Address: 18 Lapwing Close Huddersfield HD4 5FF

Application number: 2023/91405	
What is the application for?:	Erection of foodstore (class E) with associated access, parking, servicing area
Address of the site or building:	Part of former St Luke's Hospital site, Blackmoorfoot Road, Crosland Moor, Huddersfield, HD4 5RA
Postcode:

drawing title
Proposed Site Plan

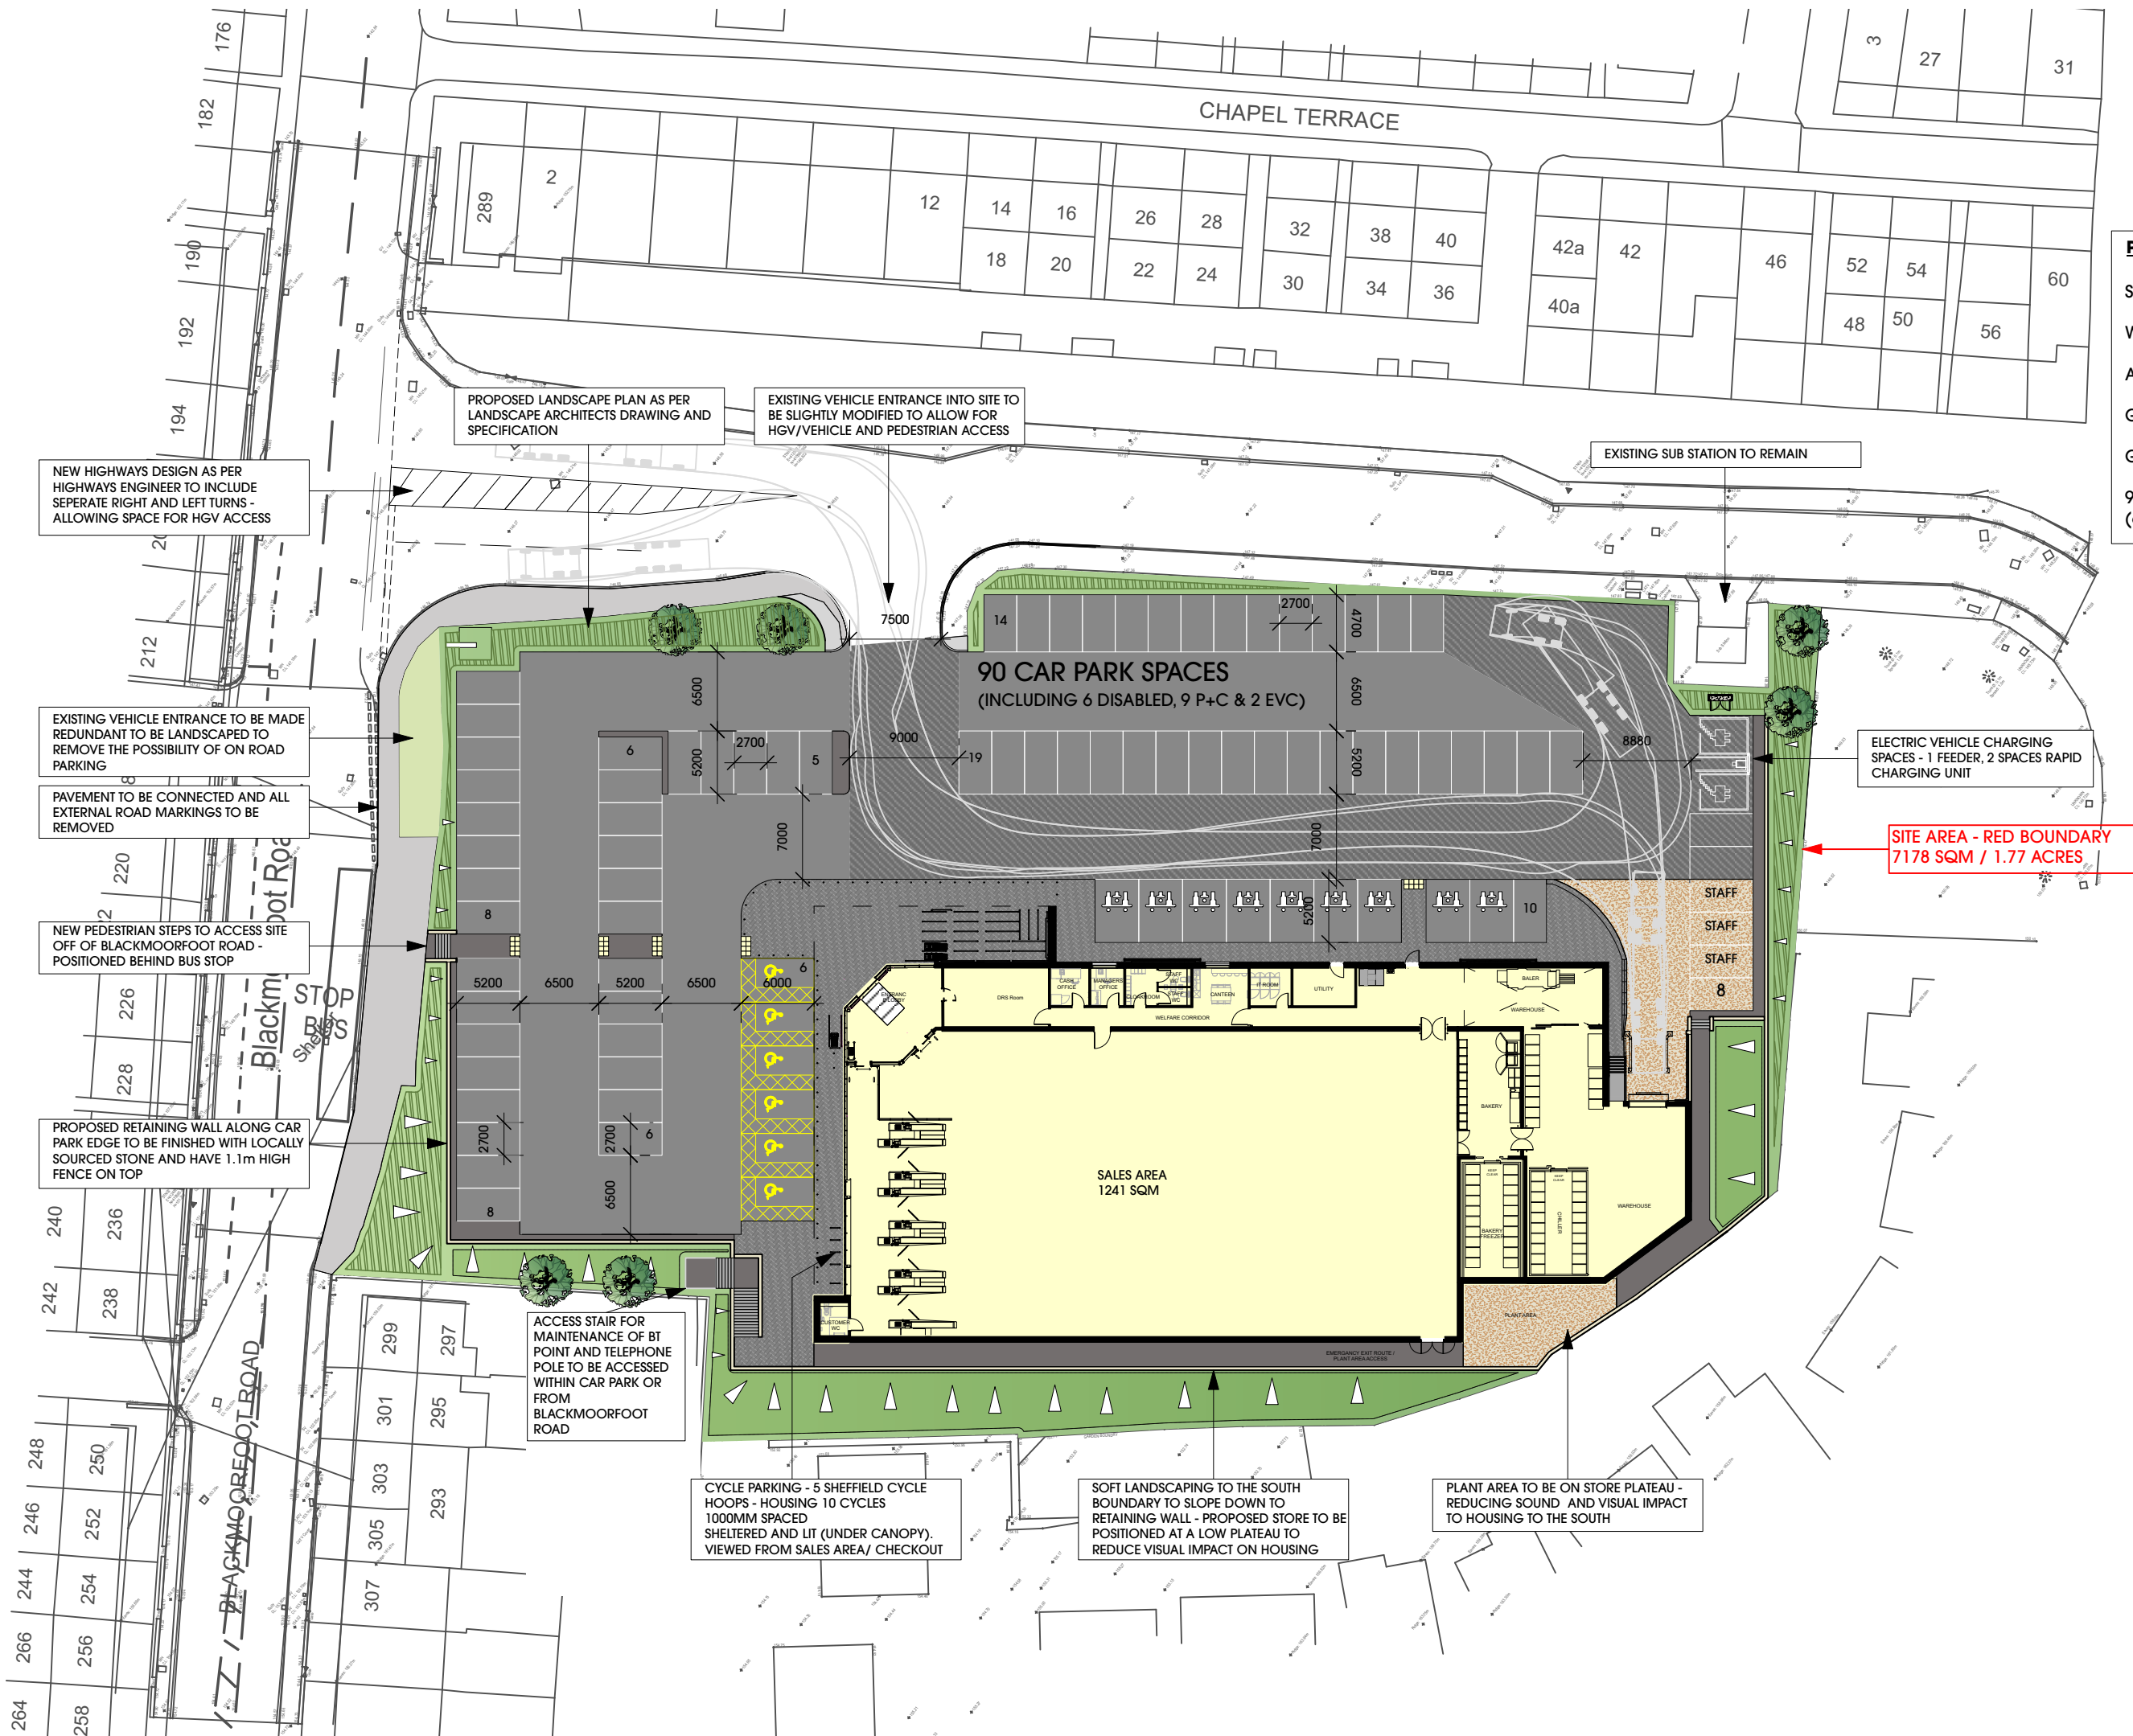
Type of comment: An objection	
Do you wish your comments to be published on the website anonymously?	No
<p>All for the idea of the Lidl, however, living on the new build estate I already know the difficulties of getting on and off the estate via turnstone way with the cars that park either side of the road that actually belong to the terrace houses on blackmoorfoot road. It's already an inconvenience that these cars believe they have the rights to park on our estate and the application wants to add more traffic to an existing issue. The entrance to the carpark should be directly from blackmoorfoot road further up the hill. There is already a junction that was there previously which is currently getting used as a private driveway for someone again, who lives in one of the terraced houses opposite. Why can't this junction be used instead? When purchasing my house I was not informed of any retail units, let alone ones with access from the site. If planning is approved for the current junction off turnstone way, a middle turning lane needs to be added to allow the residents of the estate to still gain access without getting stuck in supermarket traffic. Double yellow lines need to be implemented both sides of turnstone way at the entrance to stop people from parking here otherwise it will become near impossible to access the site</p>
